RE: Precision Eye Center
7521 Alameda Blvd. NE
Grading & Drainage Plans
Engineer's Stamp Date: 02/28/23
Hydrology File: C19D070

Based upon the information provided in your submittal received 03/02/2023, the Grading & Drainage Plans **are not** approved for Building Permit, Grading Permit and SO19 Permit. The following comments need to be addressed for approval of the above referenced project:

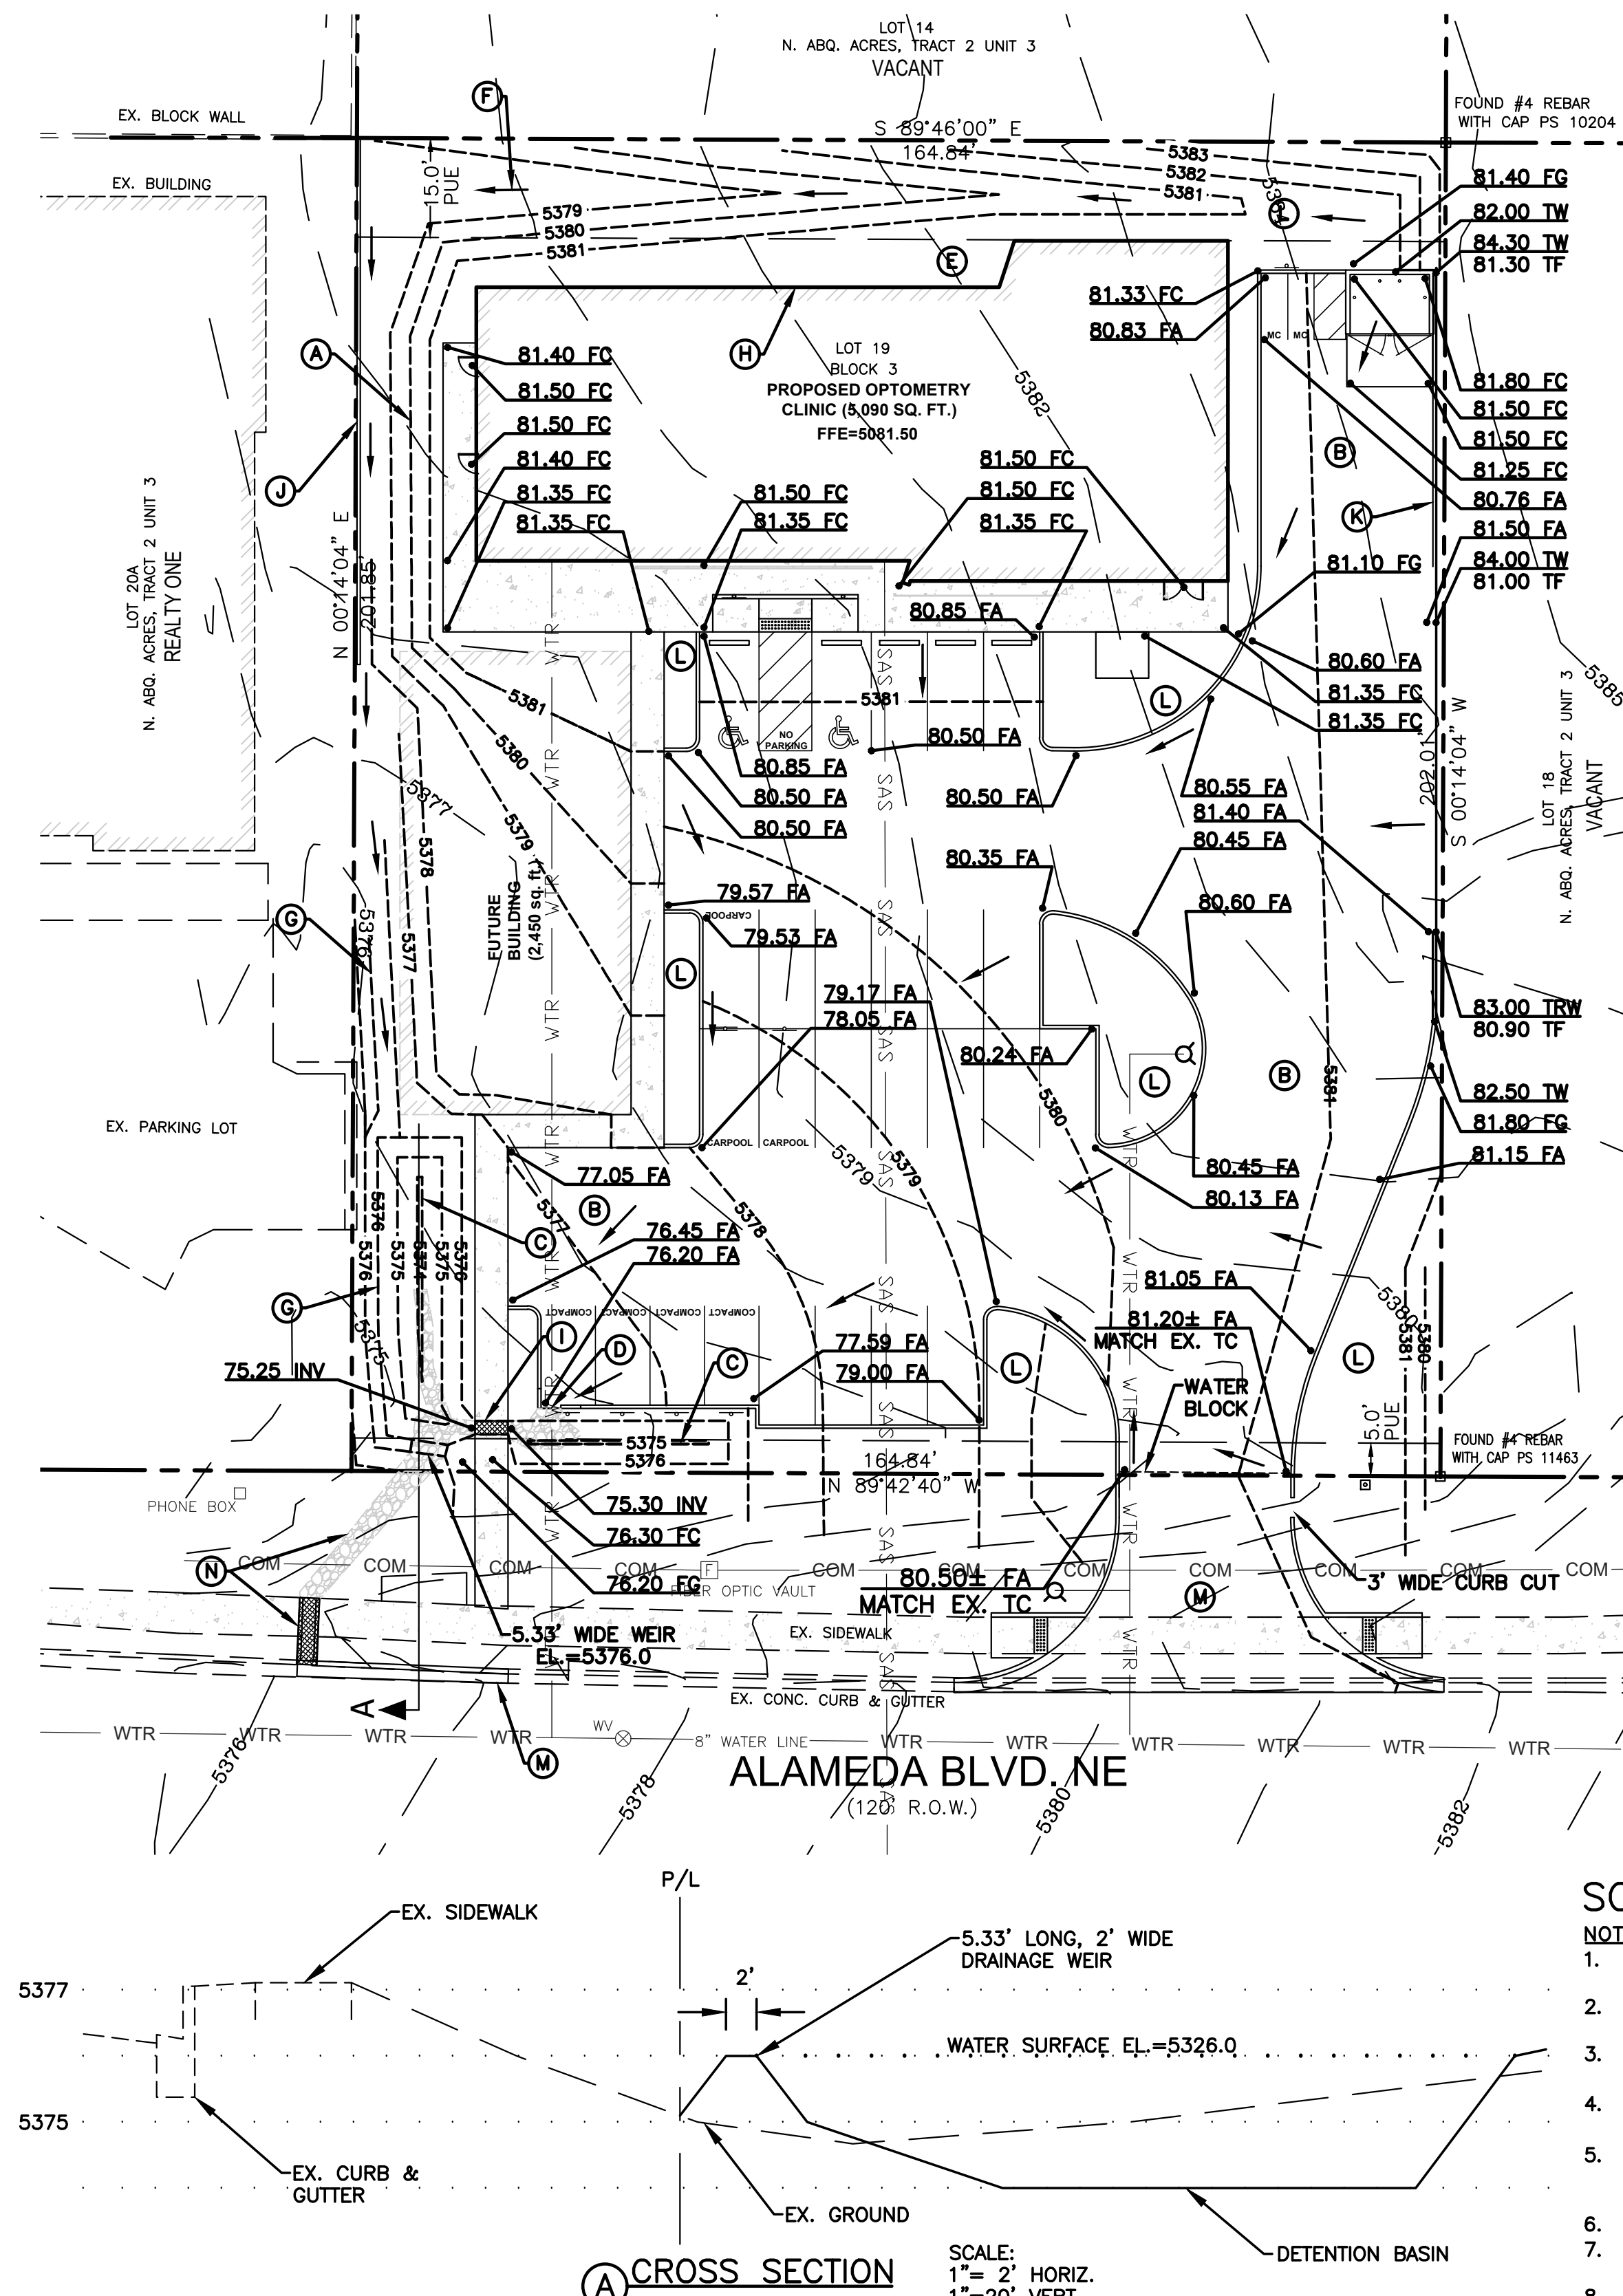
2. The project curb returns cannot extend beyond the property line. The curb return must become tangent at or before the property line, so please move the entrance about 23 ft to the west. Also, please make the other curb return tangent to the existing curb because it is currently not buildable as shown.

- The existing drive pad at the southwest corner of the property needs to be called out as "Remove existing drive pad and replace with curb & gutter and sidewalk."

- On Sheet 102, please provide a sidewalk culvert for the spillway for the stormwater quality pond to Alameda Blvd. and label per CoA Detail 2236. Please also show the invert at the pond (this is the SWQ water surface elevation) and the invert at the existing gutter on Alameda Blvd.

8. On Sheet 103, please provide the weir calculations, per DPM Article 6-16(A), for the curb cuts and sidewalk culverts. A coefficient of 2.7 is typically used for the weir equation $Q = CLH^{2/3}$.
9. On Sheet 103, please provide a cross section of the SWQ pond with the bottom of pond elevation, top of pond elevation, and SWQ water surface elevation.
10. On Sheet 102, please provide the Benchmark information (location, description and elevation) for the survey contour information provided.
11. On Sheet 102, please provide the SO-19 Standard Notes, latest version.
